CITY OF ALBUQUERQUE

March 16, 2016

**Re: Coors Blvd. – Tucson Rd. Retail Shops
Coors Blvd. and Tucson Rd.
Traffic Circulation Layout
Engineer's/Architect's Stamp 3-10-16 (G11-D031)**

| Drawn By: | BJB/DEC | | | | | | CP-102 |

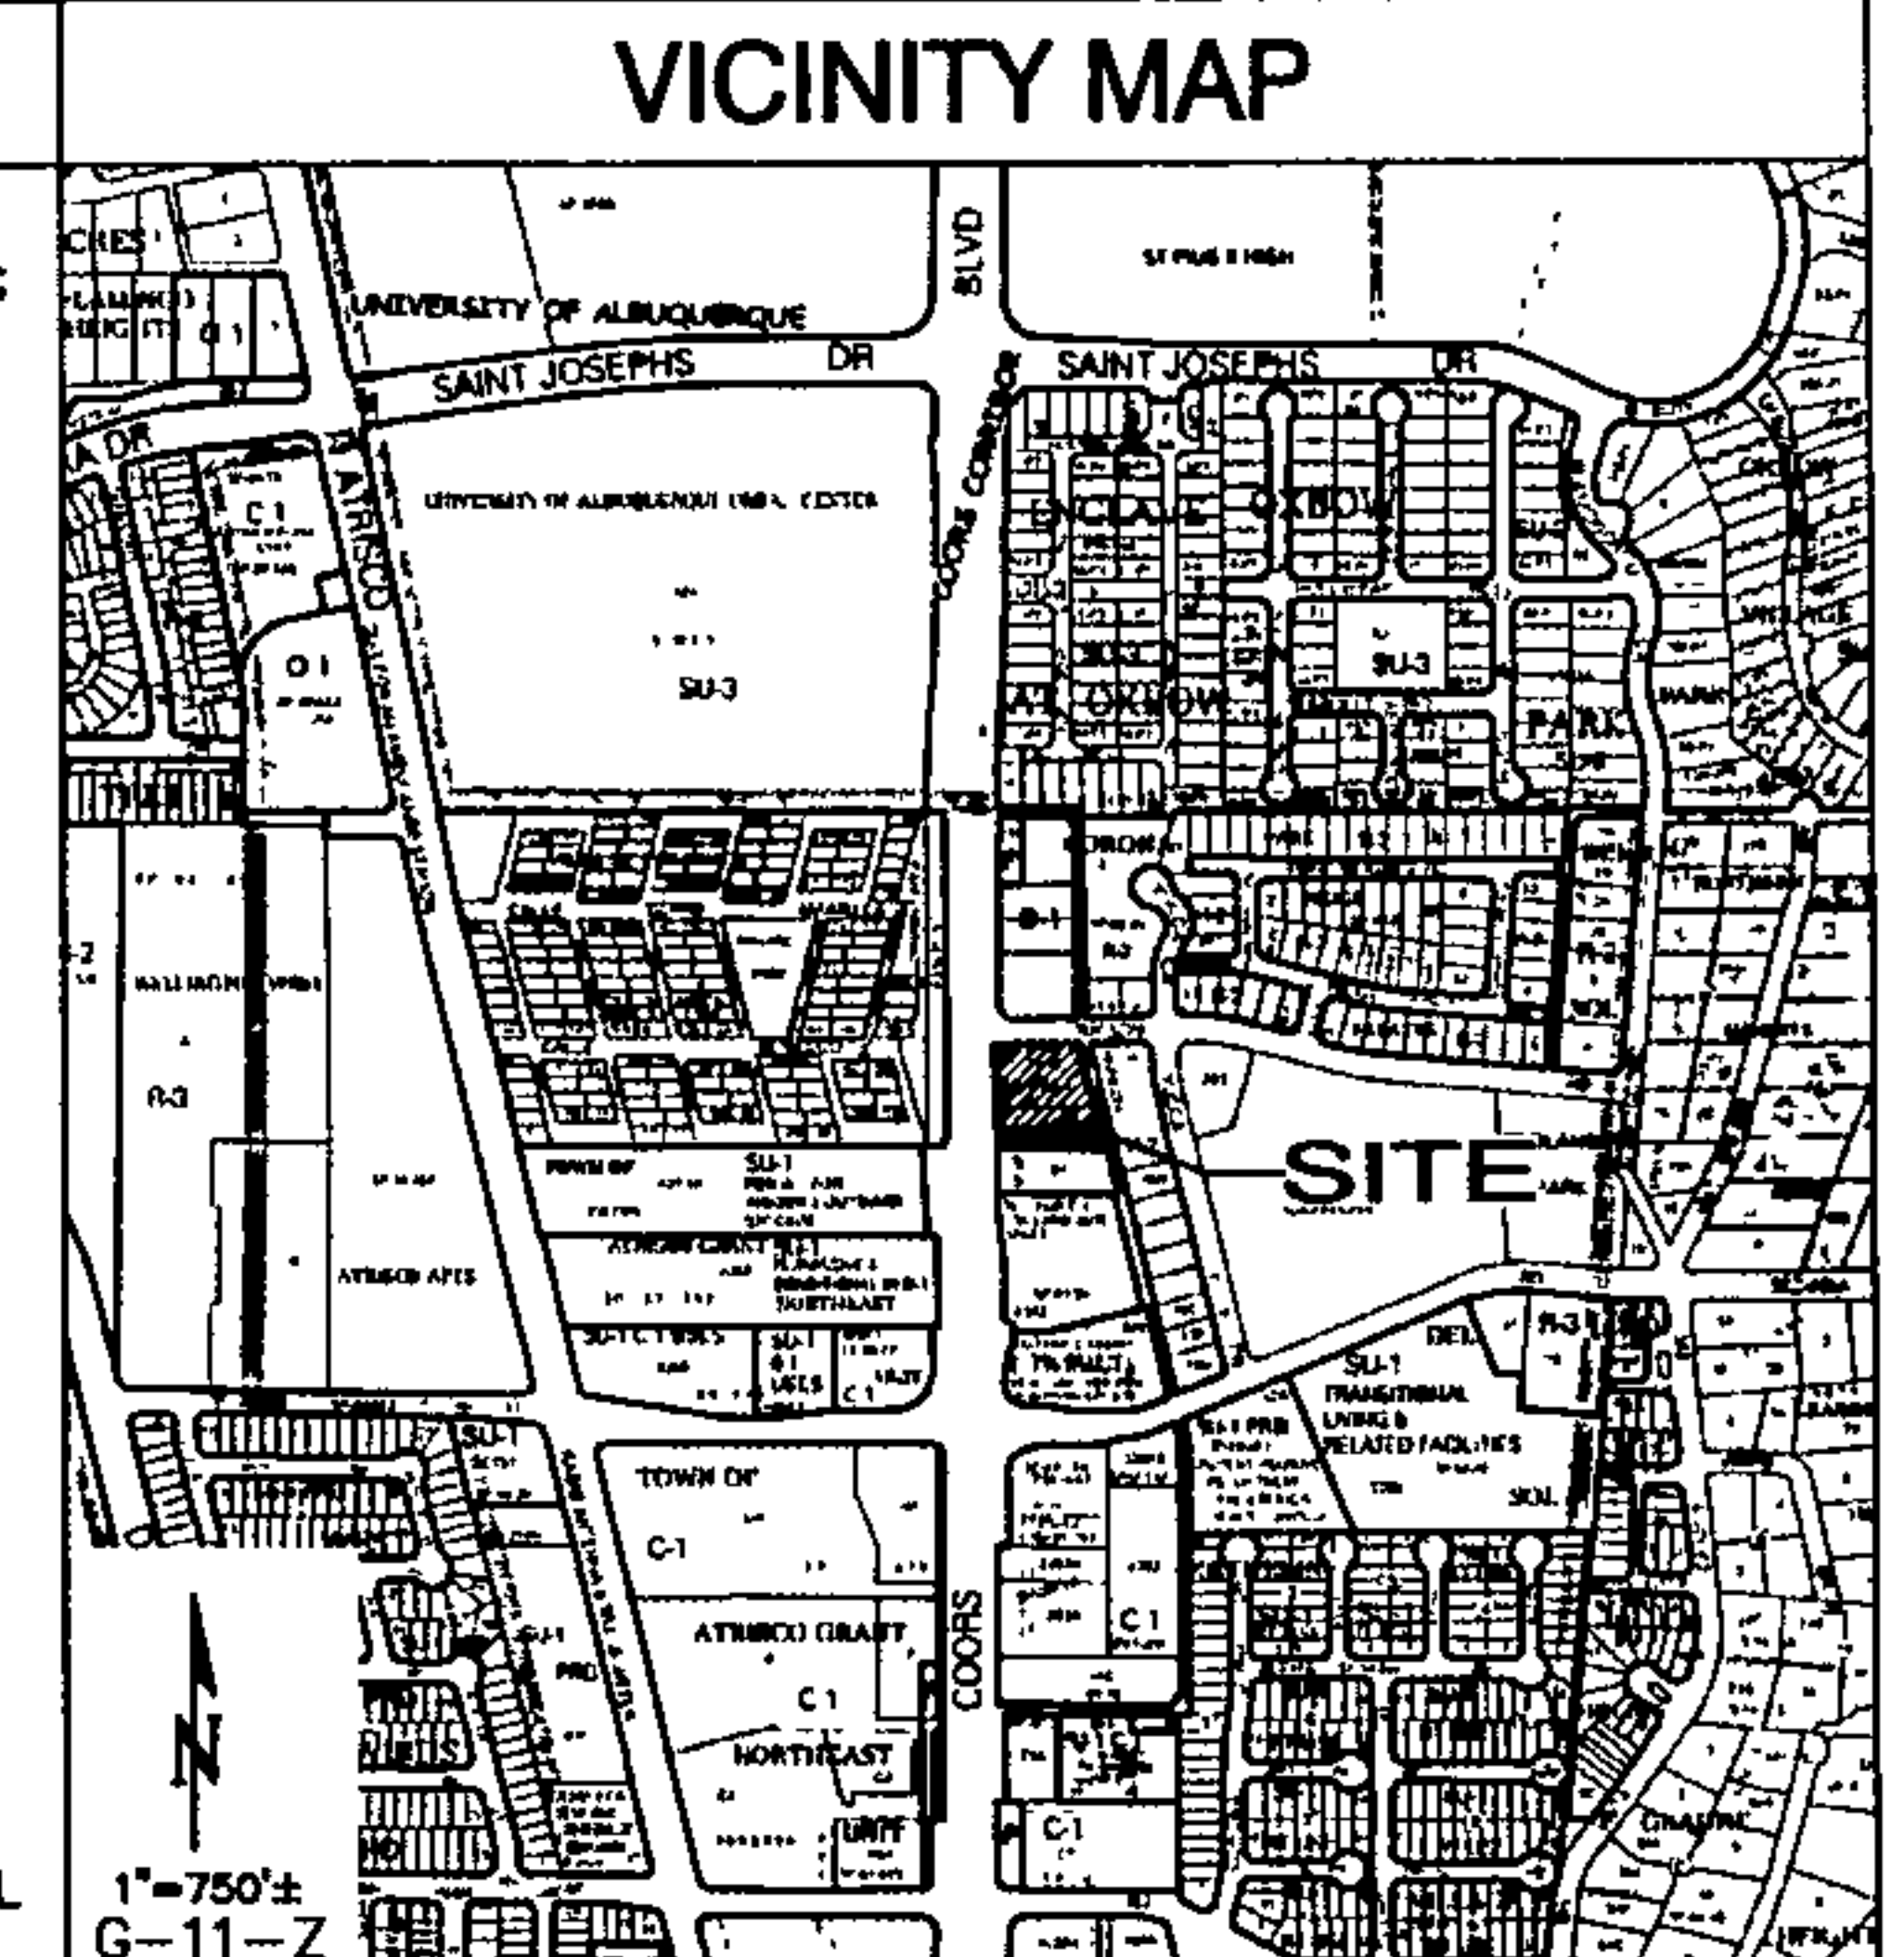
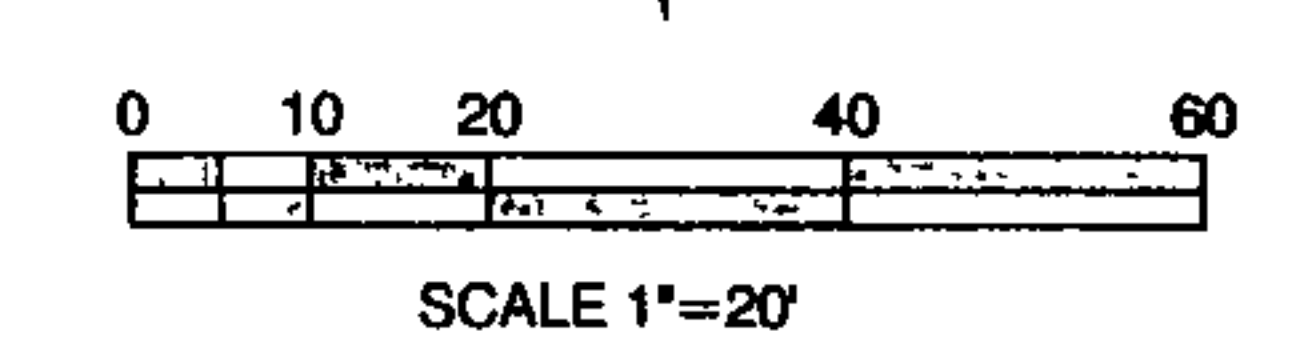
1. Clarify the extents of the current phase.
2. Please identify all existing buildings, doors, structures, sidewalks, curbs, drive pads, wall and anything that influences the parking and circulation on the site.

3. Please detail and dimension all proposed sidewalks, curb cuts, ADA ramps and intersection details. Please show all traffic directional arrows and signs.

4. Identify all existing access easements and rights of way with dimensions.
5. Identify the right of way width, medians, curb cuts, and street widths on Coors Blvd. and Tucson Rd., public alley and shared entrance south of the project site on Coors Blvd.

6. Please list the width and length for all existing and proposed parking spaces.
7. Compact parking spaces are defined and dimensioned as 8 ft. wide by 15 ft. in length. In review of submitted drawing, the parking spaces at the south east corner at 7.5 ft. wide.

8. Label the compact parking spaces by placing the words "**COMPACT**" on the pavement of each space.
9. The handicap accessible spaces must be a minimum of 8.5 ft. in width.

10. The handicap accessible spaces must include an 8 ft. wide van access aisle; all other aisles should be 5 ft. in width. Please clarify and detail the dimension of HC parking spaces.

11. The ADA accessible parking sign must have the required language per 66-7-352.4C NMSA 1978 "**Violators Are Subject to a Fine and/or Towing.**" Please call out detail and location of HC signs. Please show a detail of HC parking signs.

12. The ADA access aisles shall have the words "**NO PARKING**" in capital letters, each of which shall be at least one foot high and at least two inches wide, placed at the rear of the parking space so as to be close to where an adjacent vehicle's rear tire would be placed. (66-1-4.1.B NMSA 1978) Please show this detail.

13. Show all drive aisle widths and radii.
14. Per DPM, a 6 ft. wide ADA accessible pedestrian pathway is required from the public sidewalk to the building entrances. Please clearly show this pathway and provide details from Coors Blvd. and Tucson Rd.

15. Per DPM, a 6 ft. wide ADA accessible pedestrian pathway is required from the HC parking stall access aisles to the building entrances. Please clearly show this pathway and provide details of pathway and HC ramps.

16. Provide a min 6" or max 8" high concrete barrier curb or other acceptable barrier between landscaping and parking areas and/or drive aisles. Please call out detail and location of barrier curb. Please call out detail and dimension of curb barrier.

17. Design delivery vehicle route needs to be shown.
18. Service vehicle and/or refuse vehicle maneuvering must be contained on-site; provide a copy of refuse approval.

19. Please provide a sight distance exhibit (see the *Development Process Manual, Chapter 23, Section 3, Part D.5 Intersection Sight Distance*). Please call out this detail for the intersection of Coors Blvd. and Tucson Rd. Provide a clear sight details for all entrances and exits off of Coors Blvd. and Tucson Rd. per DPM requirements for residential roads and alley ways.

20. Please add the following note to the clear sight triangle: "Landscaping and signage will not interfere with clear sight requirements. Therefore, signs, walls, trees, and shrubbery between 3 and 8 feet tall (as measured from the gutter pan) will not be acceptable in this area."
21. Please include a copy of your shared access agreement with the adjacent property owner.

22. See Chapter 23, Section 6 of the City of Albuquerque *Development Process Manual*, for appropriate drive pad widths.
23. Unused curb cuts must be replaced with sidewalk and curb & gutter. A build note must be provided referring to the appropriate City Standard drawing.
24. All broken or cracked sidewalk must be replaced with sidewalk and curb & gutter. A build note must be provided referring to the appropriate City Standard drawing.
25. Please include two copies of the traffic circulation layout at the next submittal.
